BE/91/21/L

The Chase 101 North Bersted Street Bersted PO22 9AF

Listed building consent to restore the original wall, re-point with hydraulic lime, using existing stones, brick and flint. To remove/demolish the new addition above original wall. (This application may affect the character and appearance of the North Bersted Conservation Area and a listed building).

EXISTING WALLS

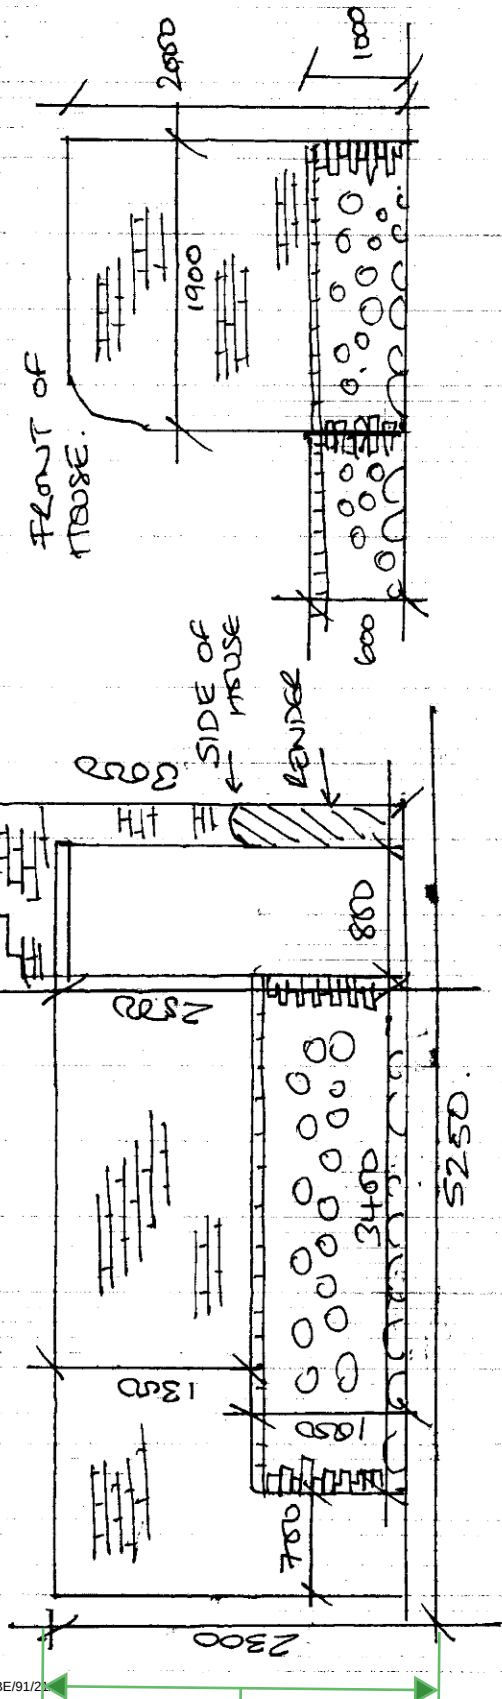
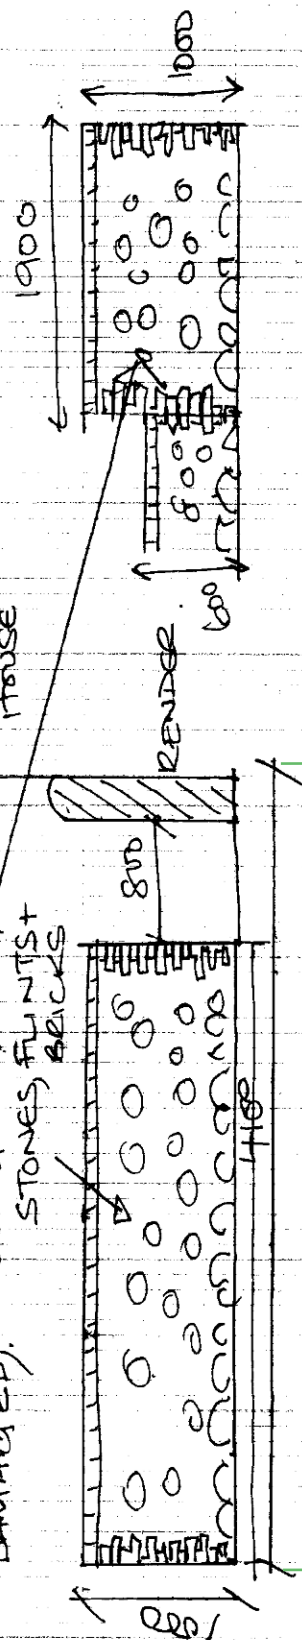
The proposed elevation plans include the following text 'using existing stones, flints and bricks'. This text appears to apply to the lower section of the walling is to be re-built, and is in contrast to the heritage statement which states that the intention is to demolish the wall above the original stone and flint wall leaving the original below it. This needs to be clarified as it would affect historic fabric.

It would also appear from the proposed elevations that a section of brick walling on the drive elevation (closest to the road) is to be replaced. However, this causes problems in that the material used for the remainder of the walling in this section appears to be the local 'Bognor Rock'. If flint is to be introduced here, I would want to understand if this would be used to infill the area currently covered by brick, or more generally. I would not want the area of the existing

Bognor Rock to be removed and replaced by a mixture of the stone and flint. Therefore, it would help to understand in more detail how the wall will look. i.e. will the existing Bognor Rock section remain or be rebuilt in its current location and appearance, with brick quoining to be used to separate it from the new flint section. This needs to be confirmed in the form of a diagram.

At present I am of the opinion that the intention is of the section of walling is to be removed and rebuilt. Therefore, in addition to the supplementary information that I require, I am of the opinion that sample panels are required for the new sections of walling. These sample panels should be of both the flint and Bognor rock elements of the walling so as to ensure that they are of a quality that is appropriate for both the listed building and the conservation areas.

Whilst the proposed works could be acceptable, the current application is not clear in what the intention of the proposal is. Will the lower section of the wall be repaired, or the sections identified rebuilt? If it is to be rebuilt, how will it look? This information should be provided so a full assessment of the impact of the proposal can be considered and a level of harm identified.
